Please upload email to LU/71/18/NMA

Non Material Amendment Application for LU/251/15/PL

[NMA request for LU/251/15/PL](#)

| scale  | date              | rev |
|--------|-------------------|-----|
| 17110  | 02.02             | A   |

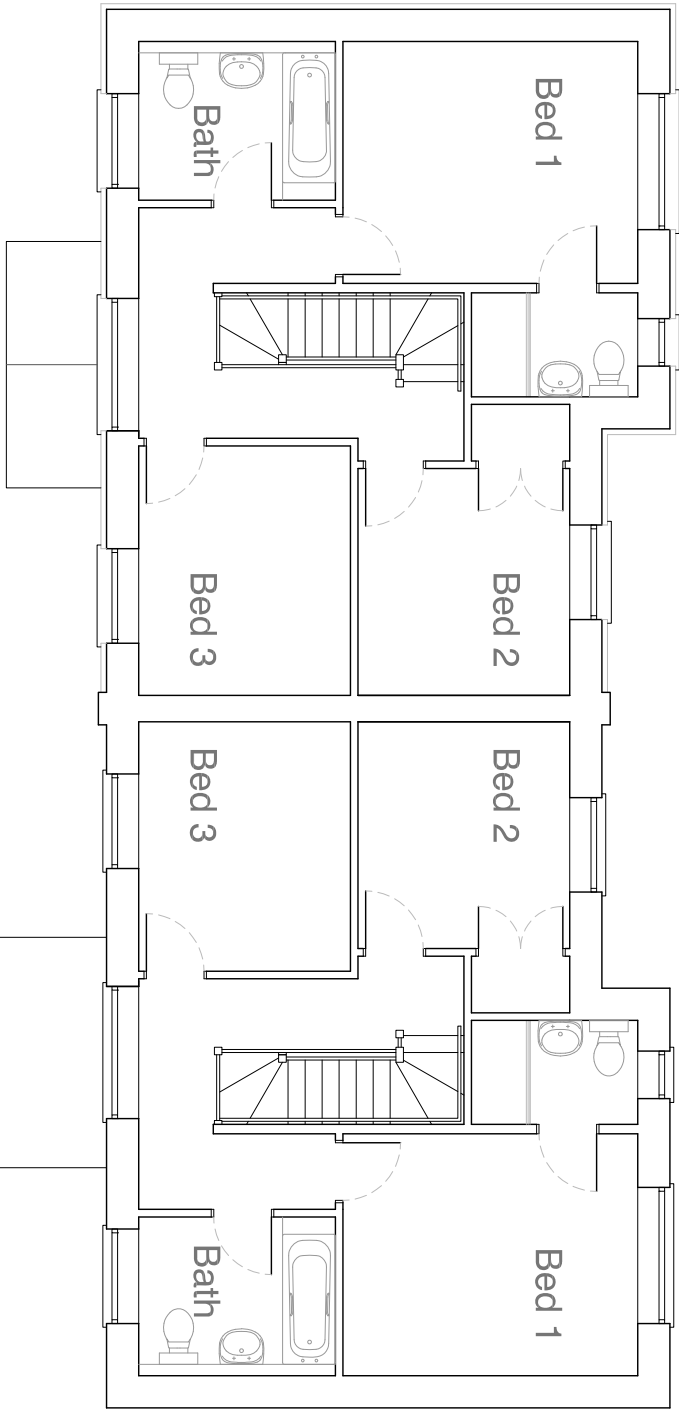
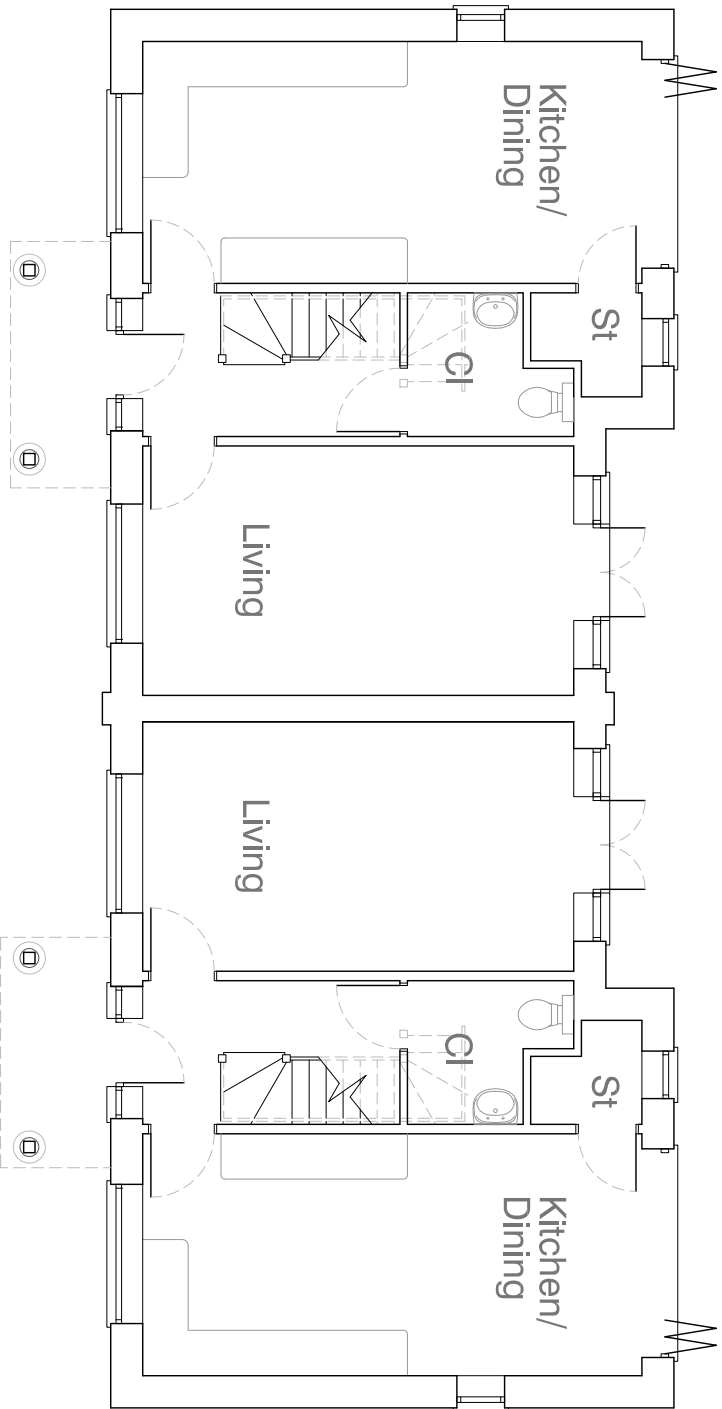
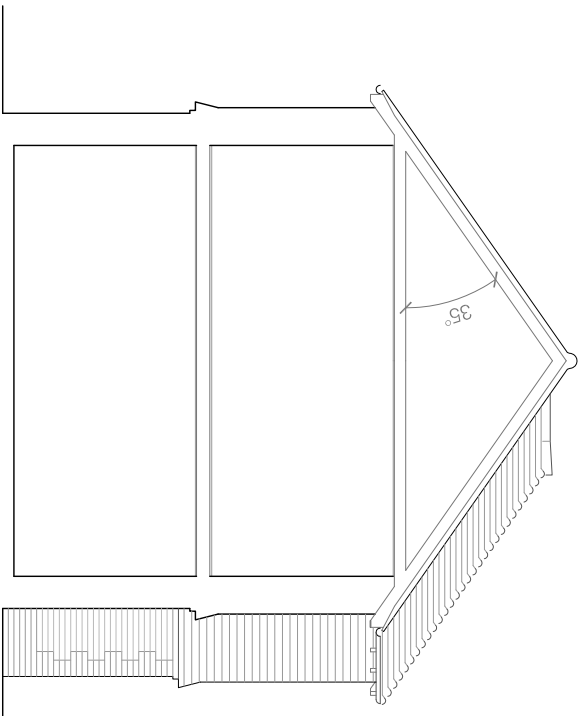
scheme in your initial proposal for an NMA. The addition of the change of materials in your final submission has not been accepted as an NMA

because ALL of the external details of the materials of construction have now been changed and it is no longer possible to reasonably assess

that the new proposed changes to the external details would not materially alter the appearance of the building.

If your client wishes to re-instate the clay tiled roof, clay hanging tiles and orange red clay bricks from the original scheme then the Council could

Further to your email of 14/04/2018, I attach substitute drawings amended to incorporate materials as originally included on the approved drawings, as suggested.
